City of Albuquerque Stormwater Construction Site Inspection Report

Project Name:	Sevano Place Subdivision Southwest Corner of Alameda and Louisiana				
Location:	Alameda & Louisiana	ESC File No.	C18E075	NPDES Id. No.	NMR10039R
Site Contact Name & Agency	Shakeel Rizi shaky1424@yahoo.com	Phone: (o)			
		Phone: (m)	505-315-6563		
Owner	Chris Kelsey- Clear Brook	Phone: (o)	505-858-1800 x:4619		
Owner's e-mail	ckelsey@stillbrooke.com	Phone: (m)	505-350-0493		
Inspection Date:	09/11/20	Start/End Time:	0735/0800hrs		
CoA Stormwater Inspector:	Timothy E. Sims				
Construction Phase:	earthwork				
Type of Inspection:	<input type="checkbox"/> Regular	<input type="checkbox"/> Storm Event	<input type="checkbox"/> Post Storm Event >0.25"	<input checked="" type="checkbox"/> 311/Complaint	<input type="checkbox"/> Follow Up

SILT FENCE

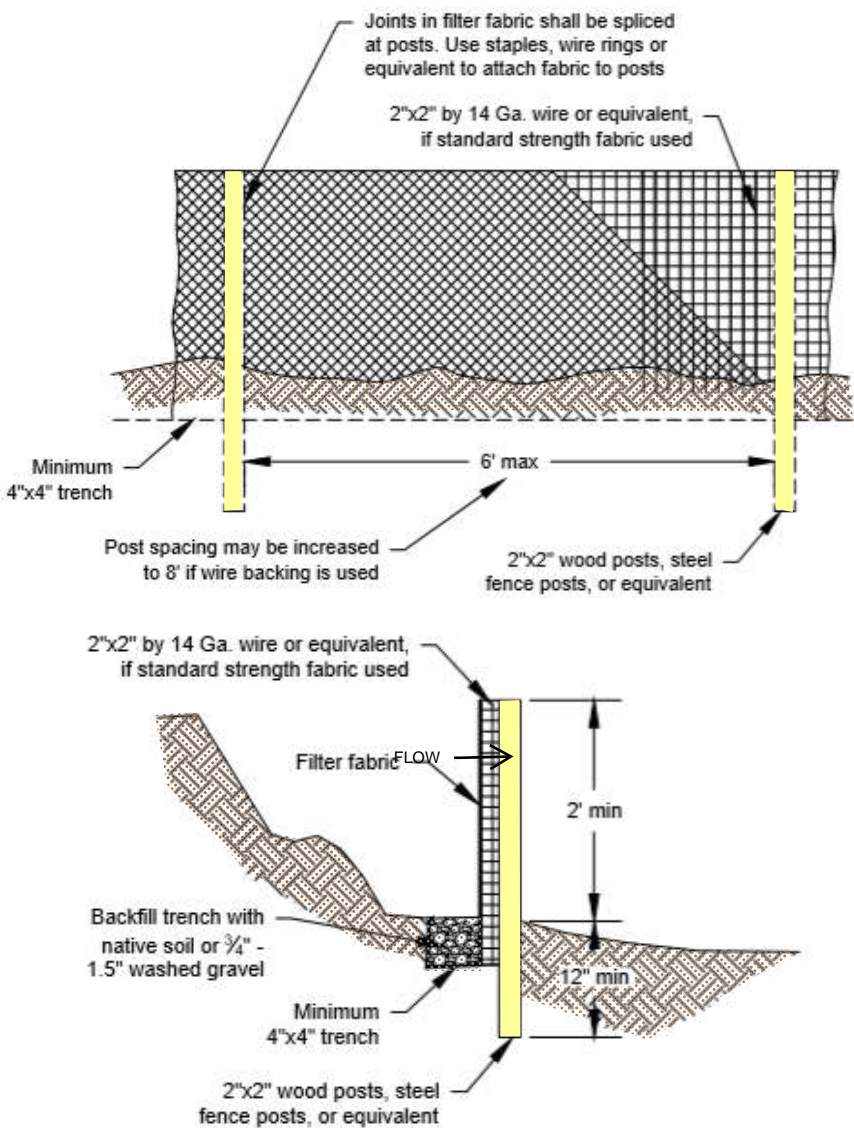
Item Number	Deficiency/ Corrective Action		
1	Provide approved NPDES posting for site.		
2	Provide SWQ approval		
3	Install BMP's per approved SWPPP design.		
4	Silt fence requires maintenance		
5	trackout pad needs to be installed.		
6	Please provide latest SWPPP self-inspection report.		
	New issues		
1a.	Sediment in Signal, from Louisiana to the western property line of 6401 Signal. Remove and prevent in future.		
2a.	Construction waste not in acceptable container. Please mitigate and provide refuse container.		
2.1	Discharge off site? (Y/N)	Yes	
4	Self Inspection Reports	requested	Latest report Date: not on file

Notes:	Inspection conducted adhering to Covid-19 constraints
	Perimeter silt fence not installed per approved designed plan.
